East Anglia One North (EA1N) and East Anglia Two (EA2) Offshore Wind Farms

Deadline 6 – 24 February 2021

Comments of Suffolk County Council as Local Highways Authority

East Anglia ONE North Offshore Wind Farm			Drg No	180476_PLN_DCO_1820.5	
Land Plans (Onshore)			Rev	04	British National Grid OSGB36
Sheet Number: Sheet 5 of 12			Date	01/03/2021	
			APFP Ref: 5(2)(i)		Doc ref: 2.2.2

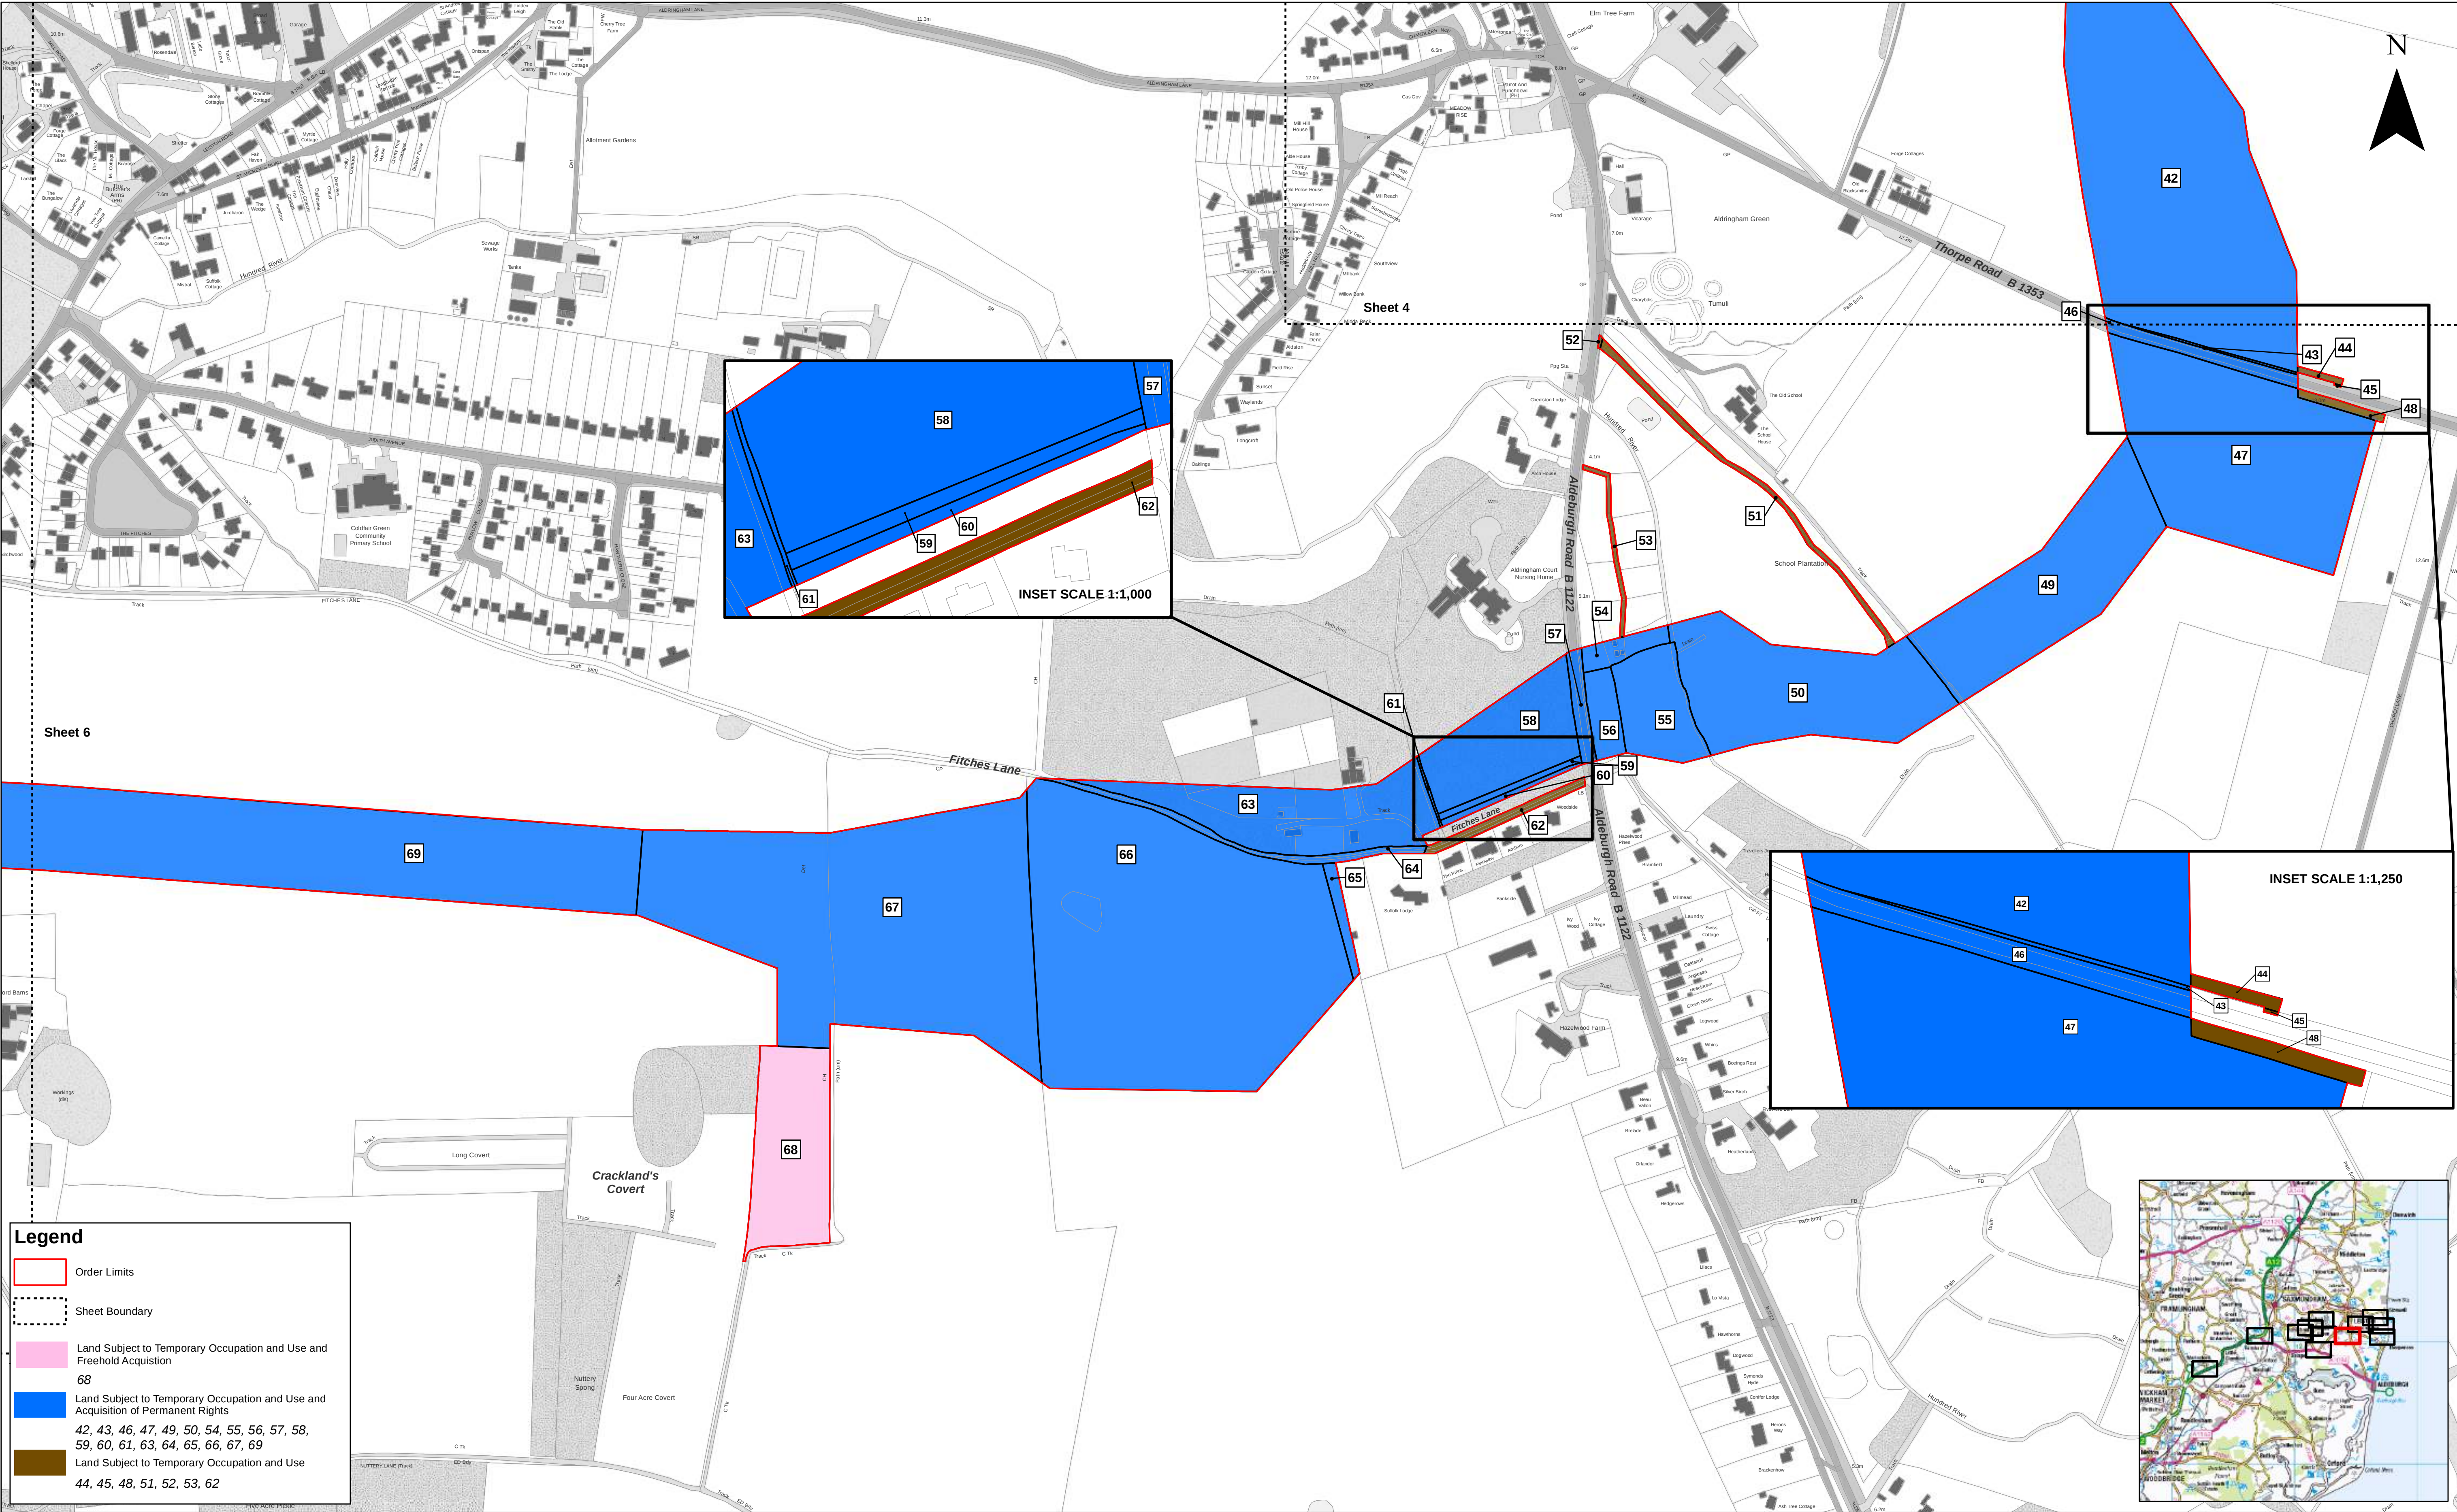
3.17 The B13153 between 5a and 5b on the land plans (onshore) is recorded as Thorpe Road rather than Thorpness Road stated in the schedule.
